Our Ref: LU/82/13/L
Your Ref:

Planning (Listed Buildings and Conservation Areas) Act 1990 (as amended)
Planning (Listed Buildings and Conservation Areas) Regulations 1990 (as amended)
Application for Listed Building Consent for Alterations, Extension or Demolition of a Listed Building

Development Application for listed building consent for the restoration of original single house from 2 No converted flats.
Location 5 River Road Littlehampton

DRAWING No.
10637P/3

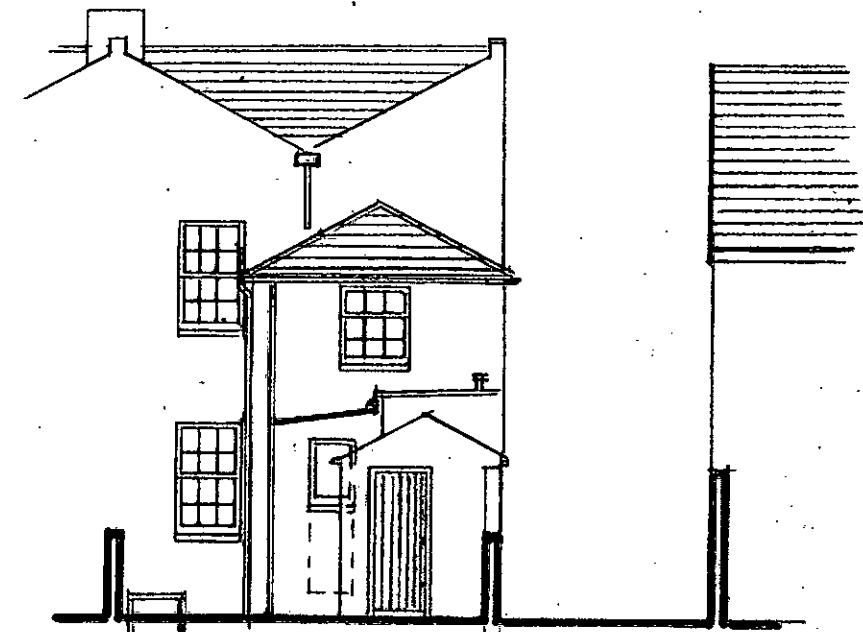
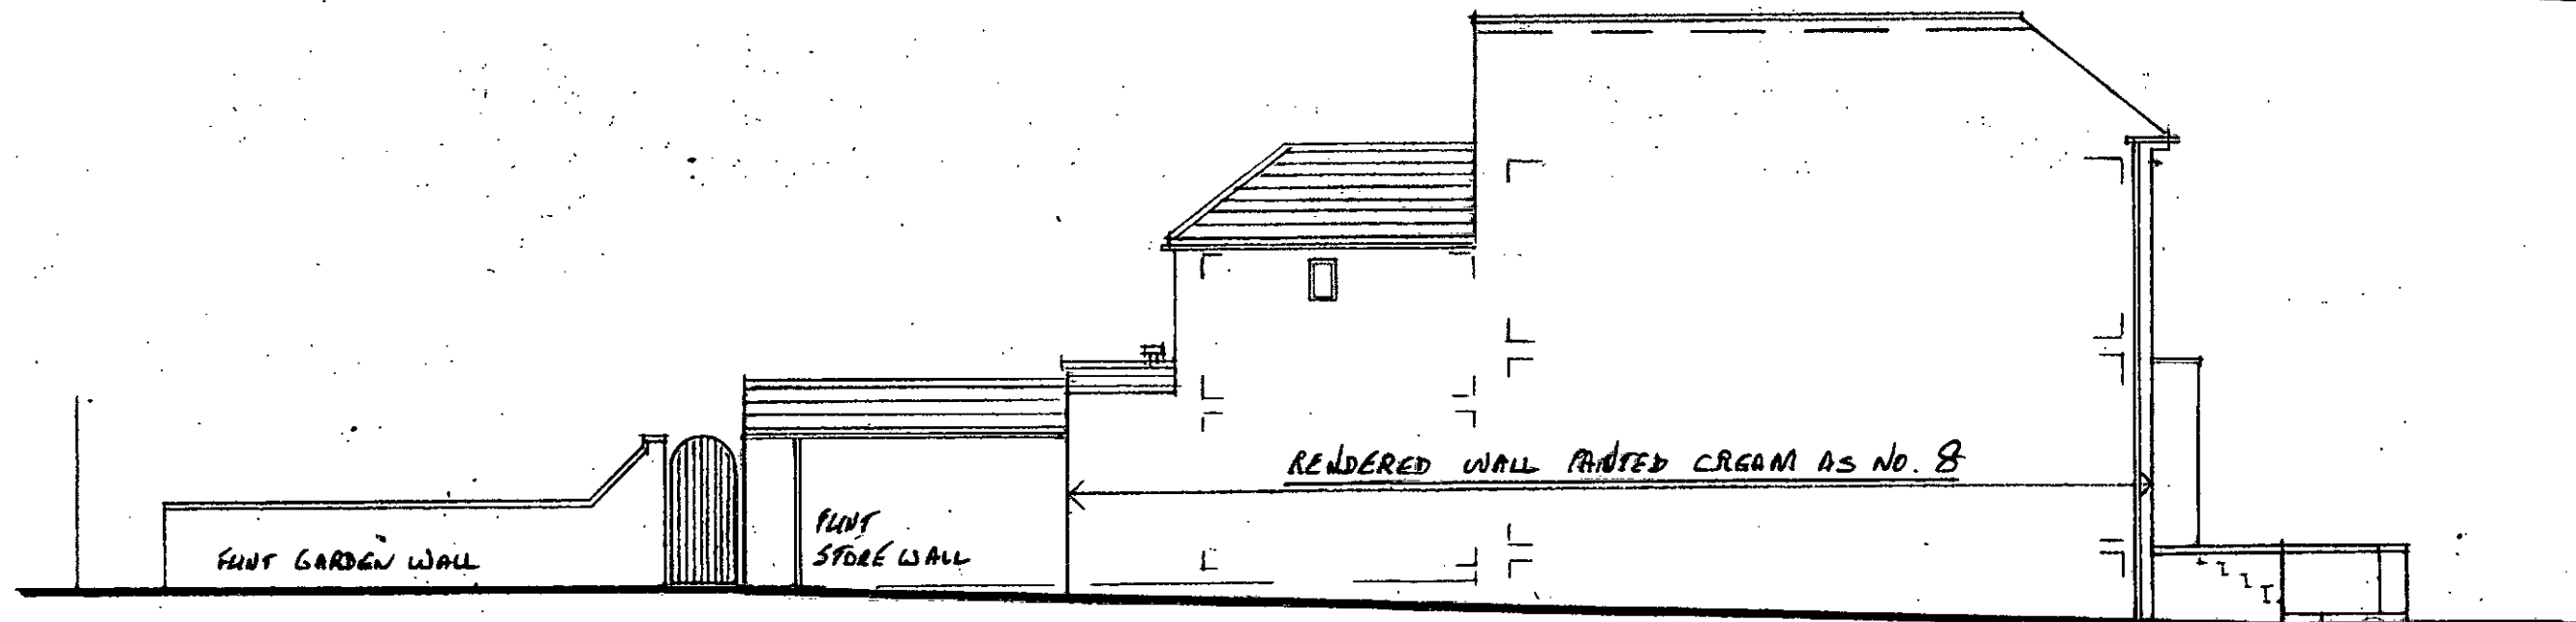
Please label the elevations as existing, proposed or if applicable, existing and proposed for clarification.

5 RIVER ROAD, LITTLEHAMPTON.
LISTED BUILDING ALTERATIONS
SITE PLAN + STREET ELEVATION

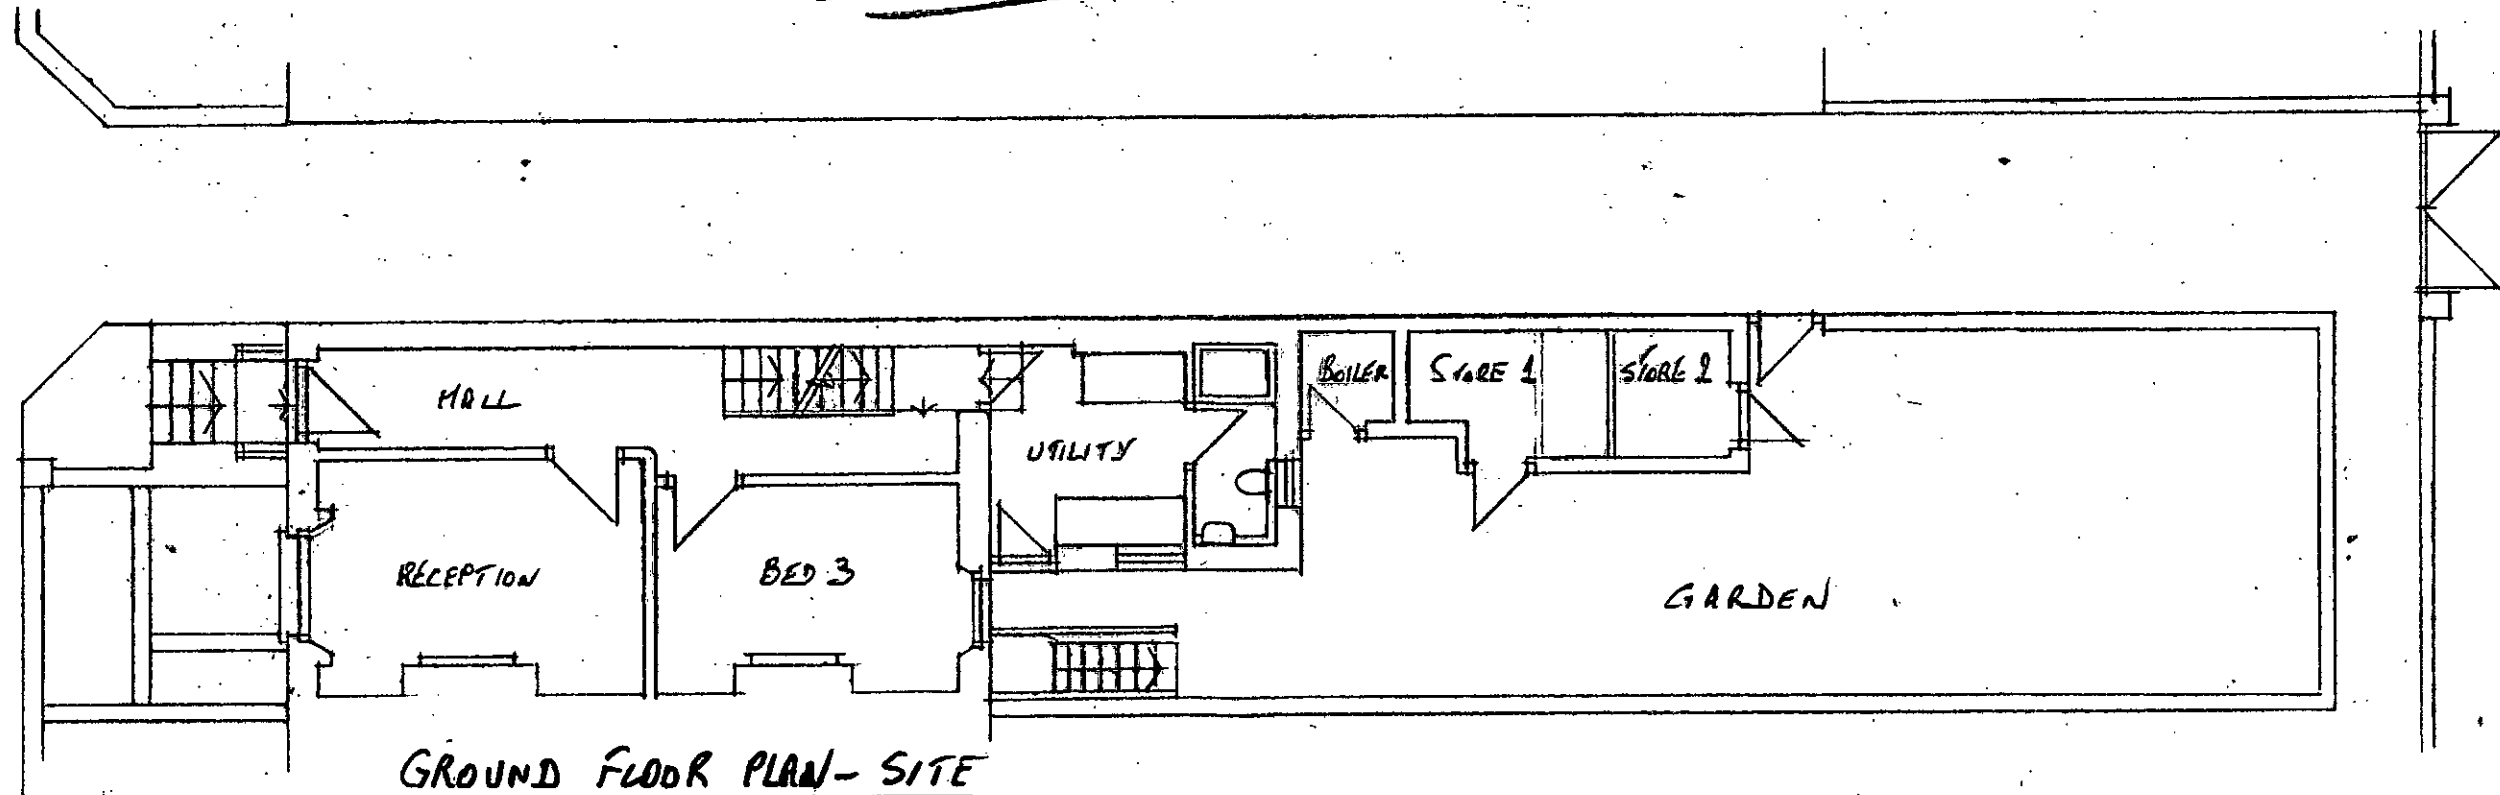
Please submit 1 electronic or 3 paper copies of a block/site plan in accordance with the guidance notes available on our website detailed below (click on National List). Please highlight/hatch the proposed works.
